**KIRKLEES METROPOLITAN COUNCIL
INVESTMENT & REGENERATION SERVICE**

**DELEGATED DECISION FOR APPLICATION FOR CERTIFICATE OF
LAWFUL DEVELOPMENT**

Reference no.: 2026/CL/91030/E

Site: 12, Fishermans Walk, Lower Hopton, Mirfield,
WF14 8QH

Drawing Title
Proposed Plans and Elevations

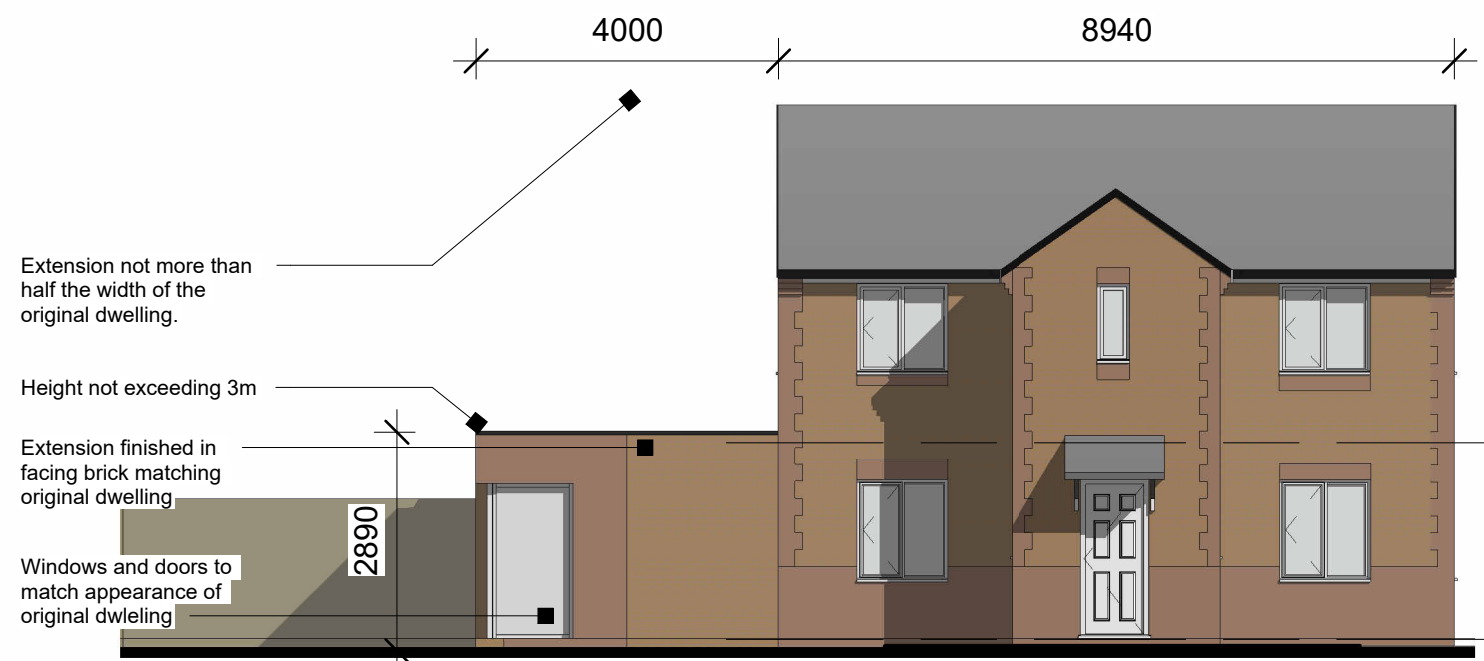
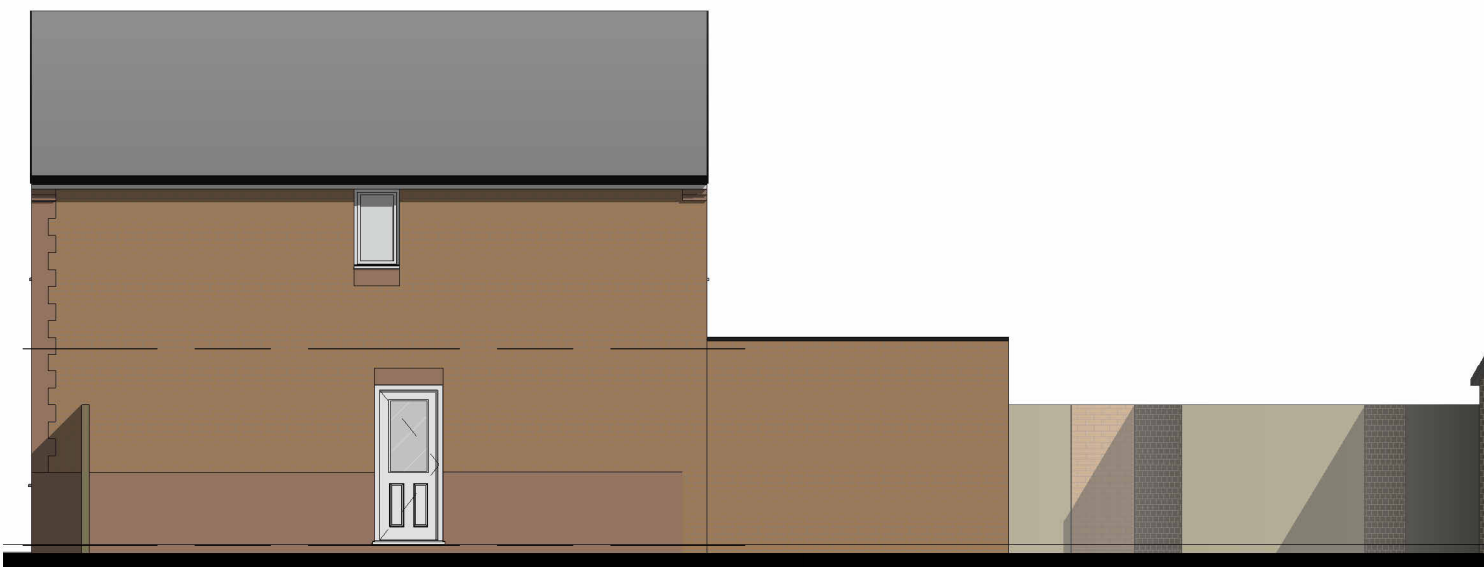
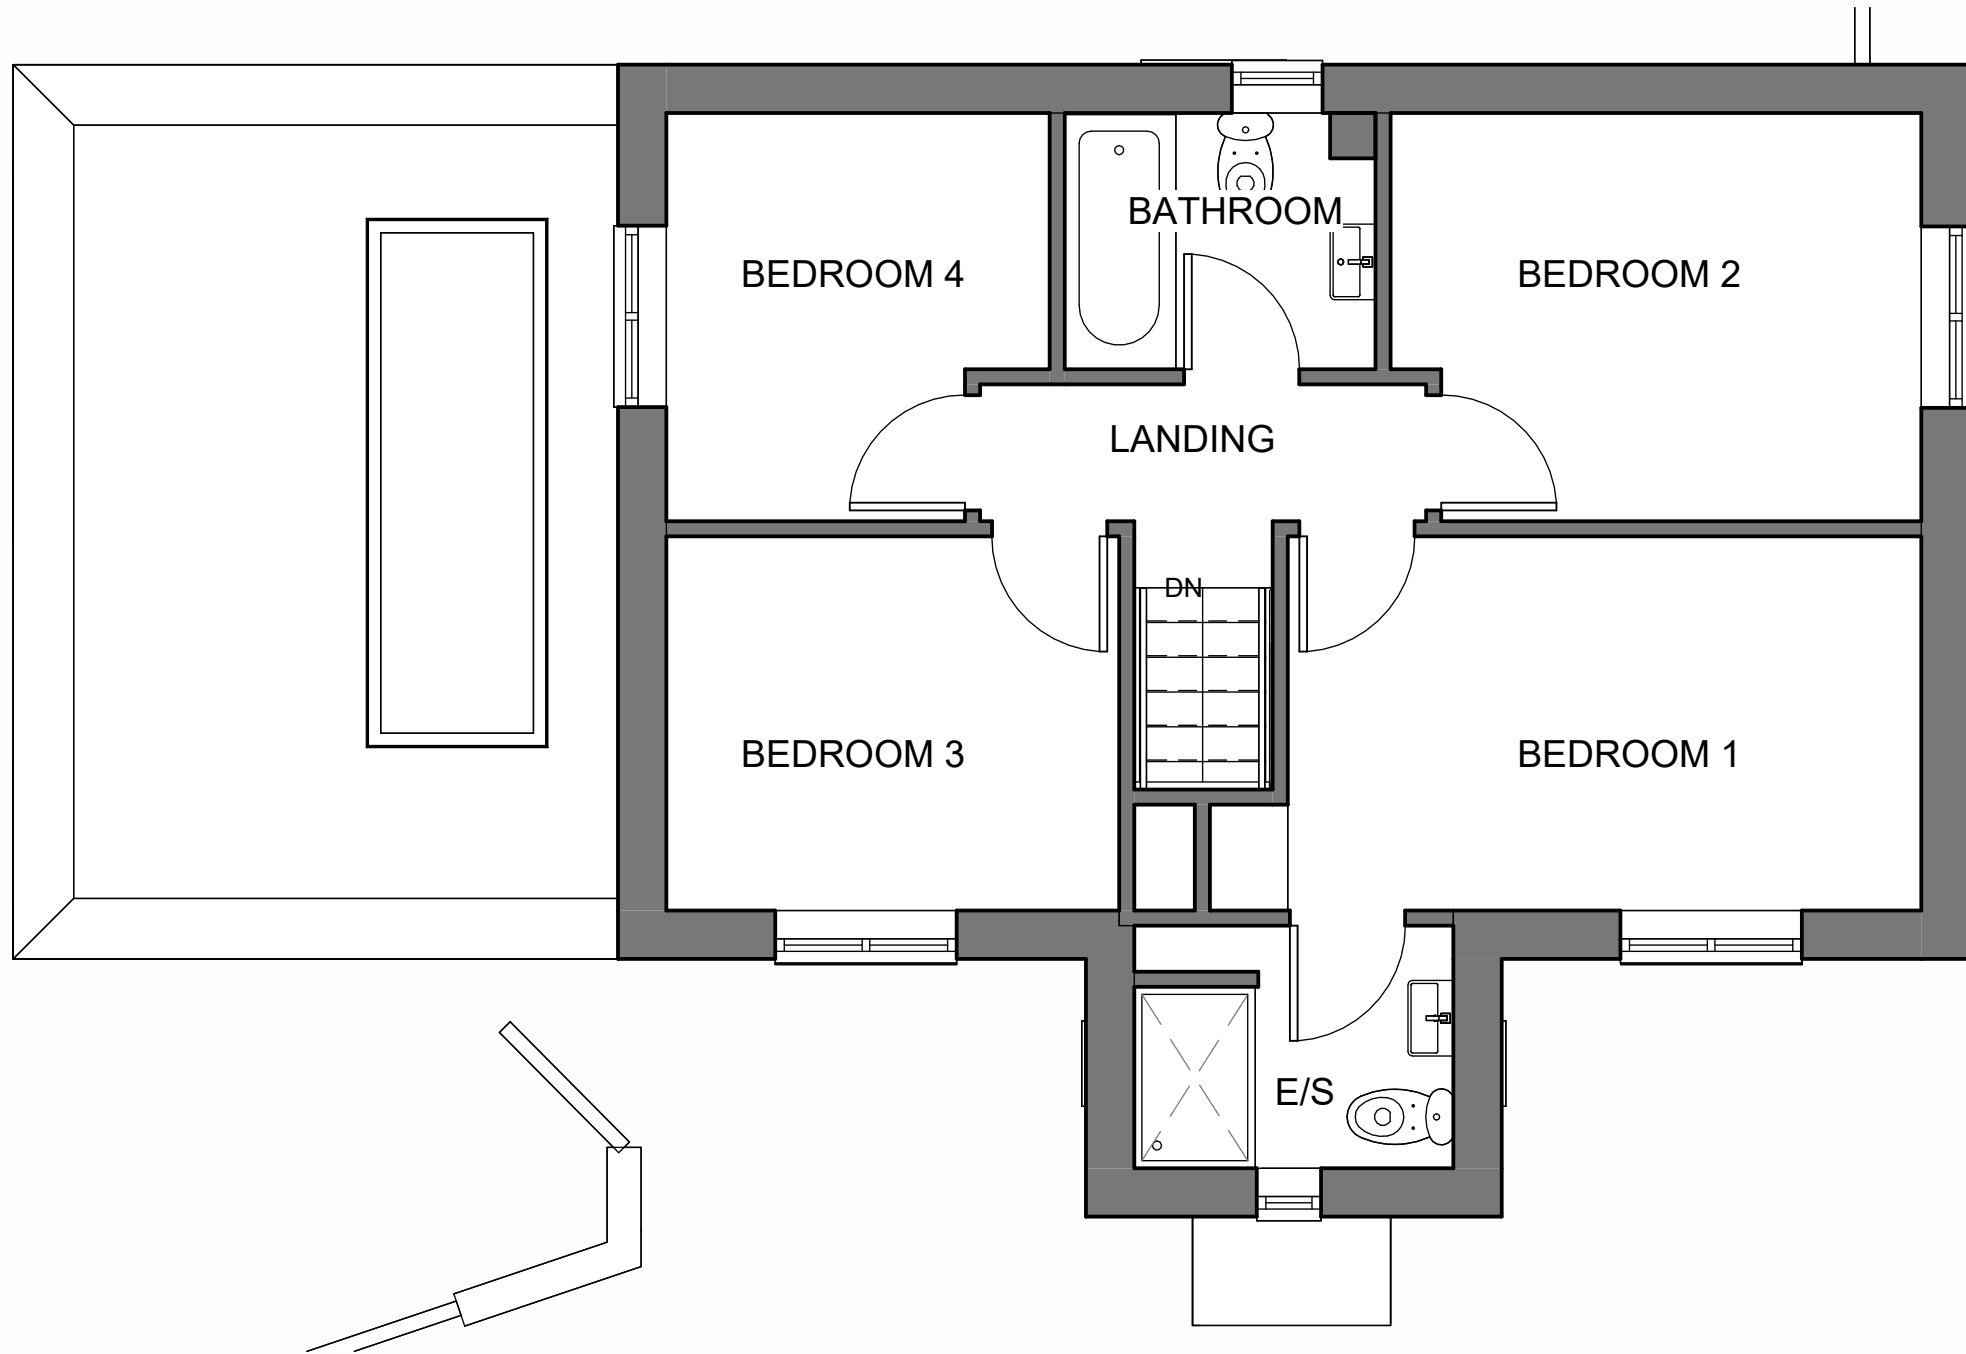
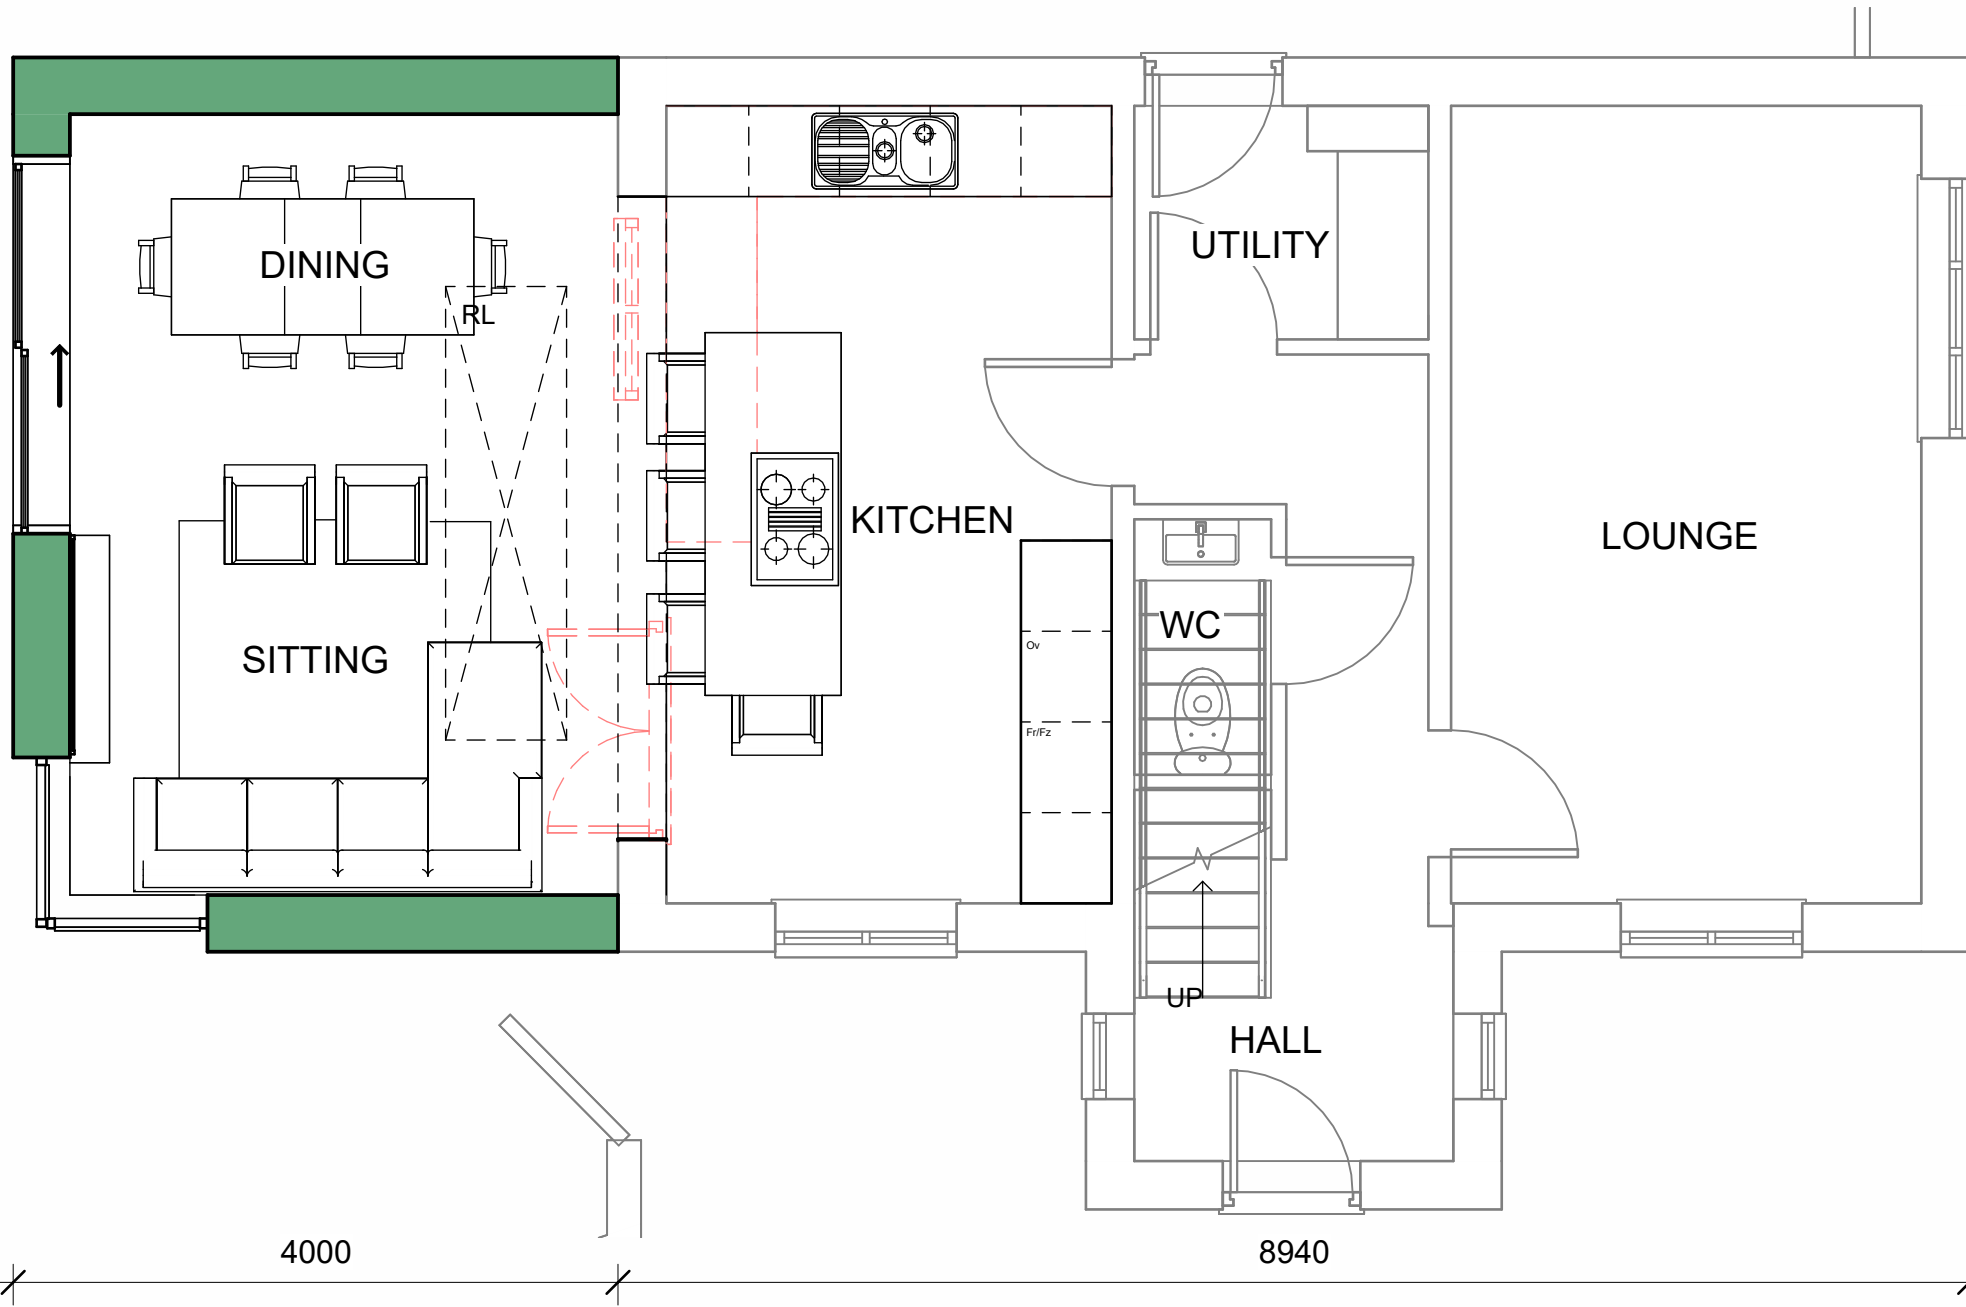
The proposed extension would lie flush with the existing front and rear elevations of the property and would project to the side by 4 metres. The extension would have a flat roof with at an overall height of 2.89 metres. It is proposed that the extension would be constructed from facing brick to match the original dwelling.

Comment: *The enlarged part of the dwellinghouse would not extend beyond a wall forming the principal elevation of the original dwellinghouse and whilst it does project beyond a wall forming a side elevation of the original dwellinghouse it does not front a highway.*

Comment: *The enlarged part of the dwellinghouse would have a single storey and would not extend beyond the rear wall of the dwellinghouse and would not exceed 4 metres in height when measured from the adjacent ground level.*

Comment: *The enlarged part of the dwellinghouse would be within 2 metres of the boundary of the curtilage of the dwellinghouse and the height to the eaves (overall height in this case as a flat roof is proposed) would not exceed 3 metres.*

Comment: *The enlarged part of the dwellinghouse would extend beyond a wall forming a side elevation of the original dwellinghouse. However, it would not exceed 4 metres in height, would not have more than a single storey and*

would not have a width greater than half the width of the original dwellinghouse.
